Our reference: BIS-32/2/1

**160 Wicks Road Macquarie Park  
Modification 1 Wicks Road Construction Support Site (SSI-8863-Mod-1)**

## **City of Ryde Submission**

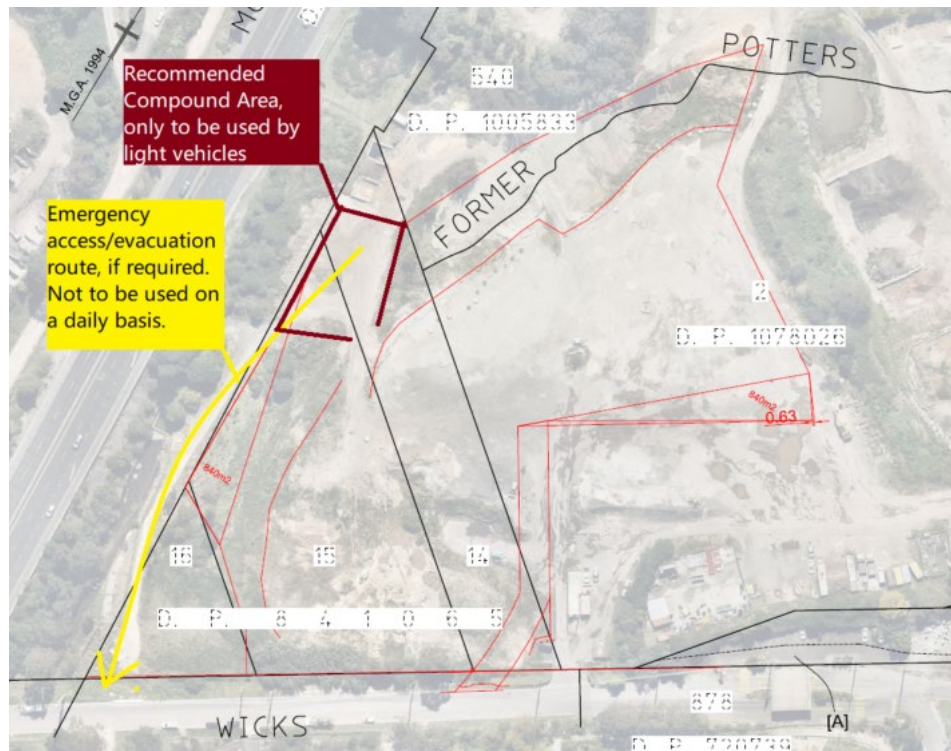
- Culvert under the site: Site usage plan is to show the exact position of the culvert including any inlet structures. With reference to the figure below, the secondary route marked yellow passes over the old culvert at its shallowest points, therefore, the use of this route must be limited to emergency use only, such as site evacuation. It should not be used on a daily basis by heavy vehicles. A pre and post construction dilapidation report on portions of the Mainline culvert lying beneath the lease area, including both CCTV images and video, will be required to be submitted to Council. Any damage is to be repaired. A Noise & Vibration

Plan is to include measures to protect the integrity of the culvert. The area outlined brown below is an area where stockpiling should be avoided. Other uses of the area marked brown, such as a site compound or light vehicle parking, is suggested.
